One Earth Solar Farm

**Draft Statement of Common Ground with the Environment
Agency**

EN010159/APP/8.11.32

November 2025

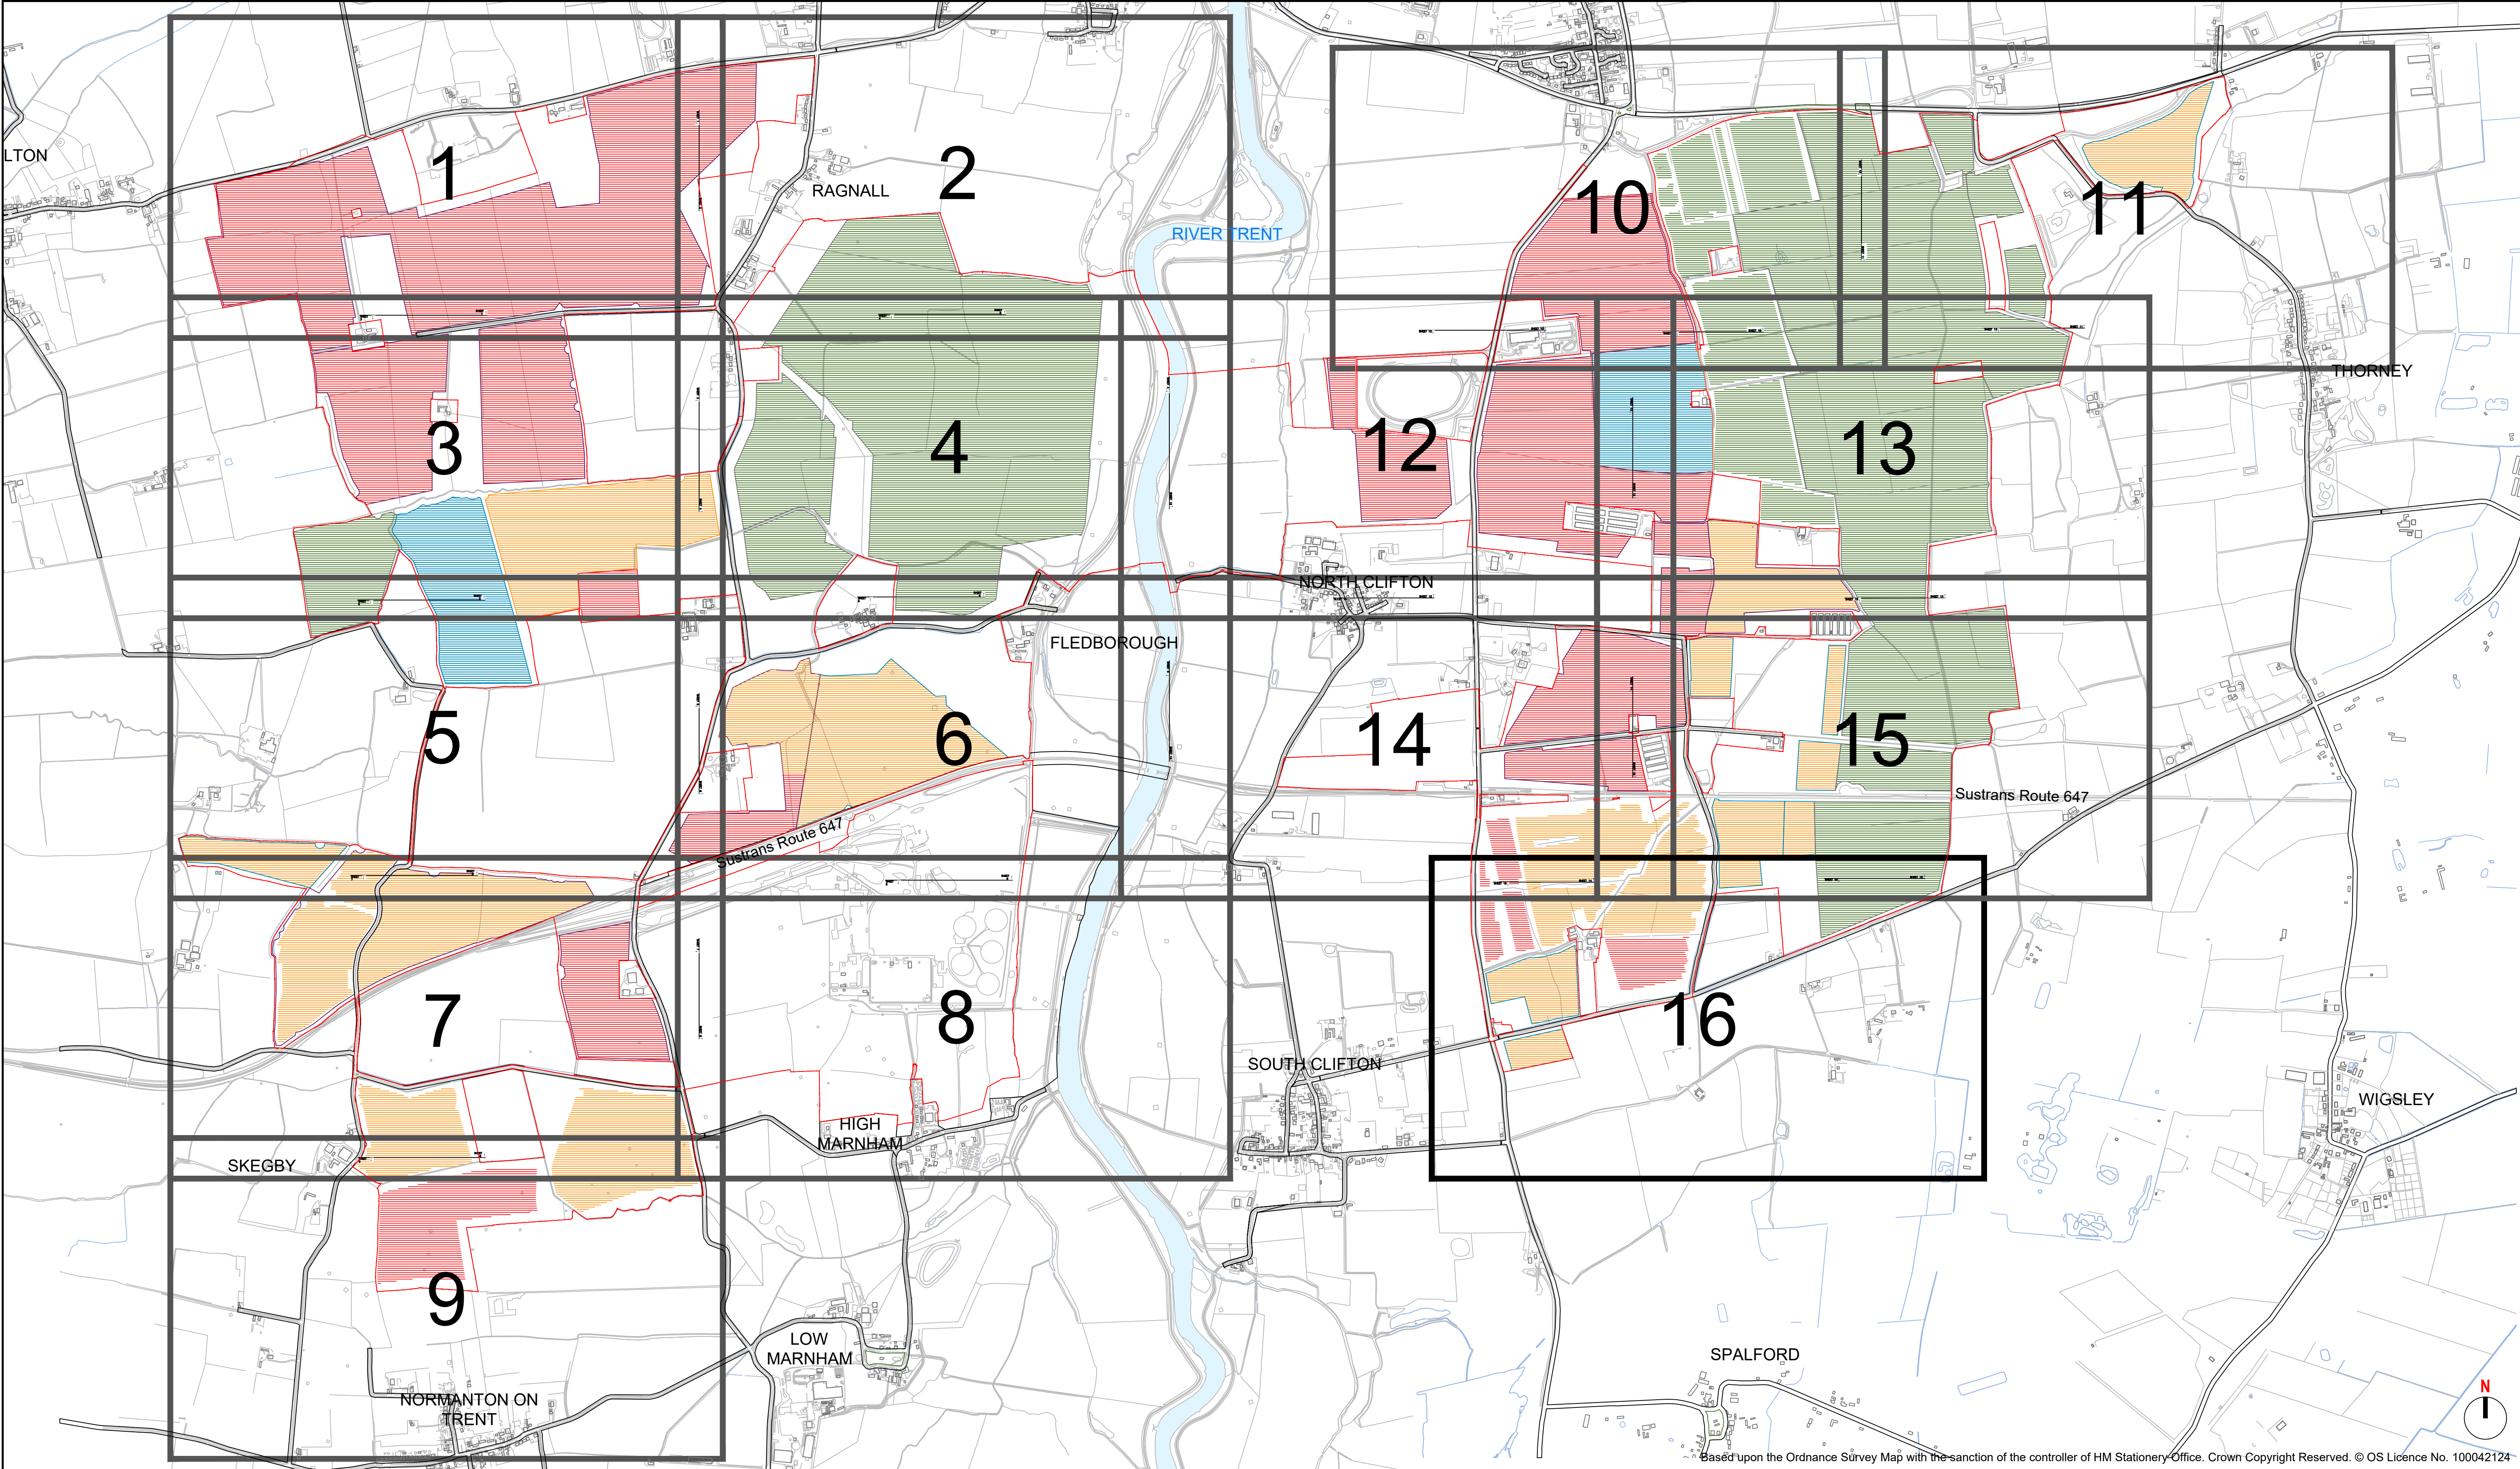
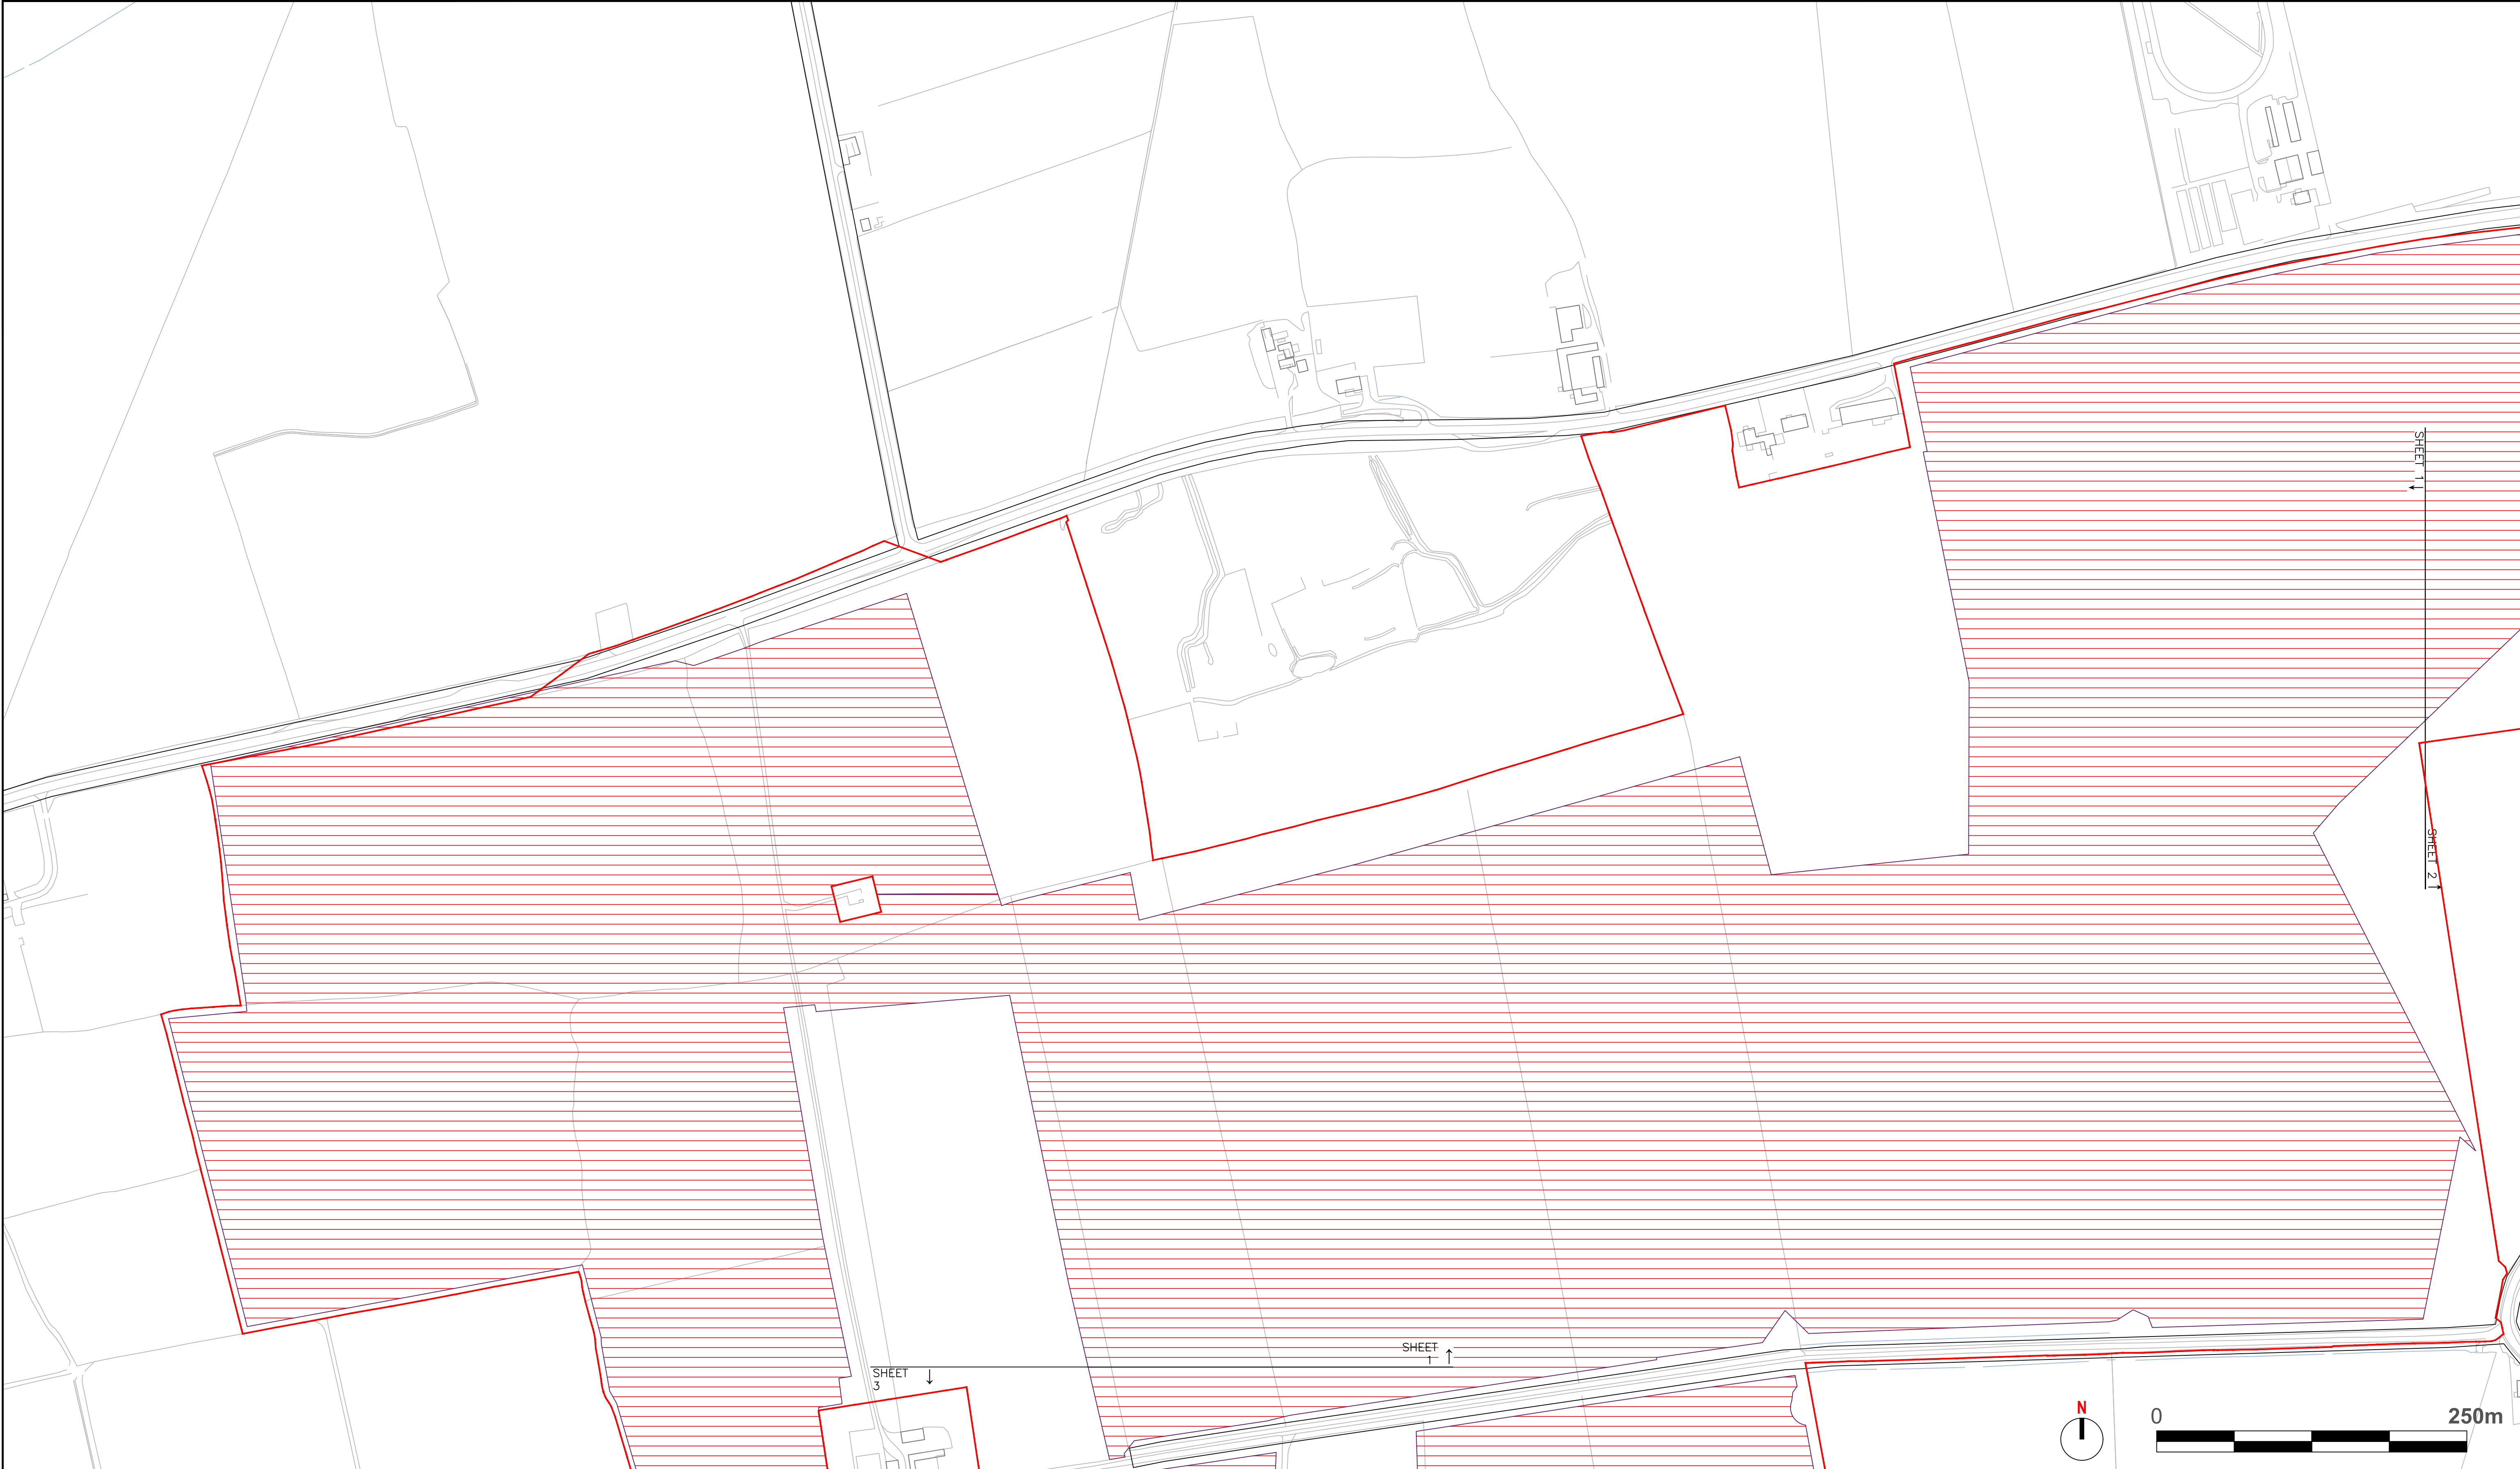
outside the design flood extent.		
02-03	Panel Raising	Applicant to provide a 300mm freeboard between the design flood level and base of panels wherever possible.	<p>It is proposed that a minimum of 300mm freeboard be provided across the majority of the Site by raising the bottom of panel heights. There are however, some localised positions where panels do experience a lesser freeboard.</p> <p>As a minimum, the base of the panels will be raised as required to ensure that the panels do not become submerged. This is achieved by adjusting the panel angle (within the 10 – 25 degree as set out within the outline design parameters) or by removing the bottom row of panels.</p> <p>By taking the above approach, it is confirmed that during the design flood event, the panels will not be submerged at any location within the Proposed Development, thereby ensuring the panels themselves will not impact flood flows or storage capacity.</p> <p>The EA have confirmed this matter is agreed following review of an updated draft of the FRA. The updated FRA will be submitted at Deadline 5.</p>	Agreed
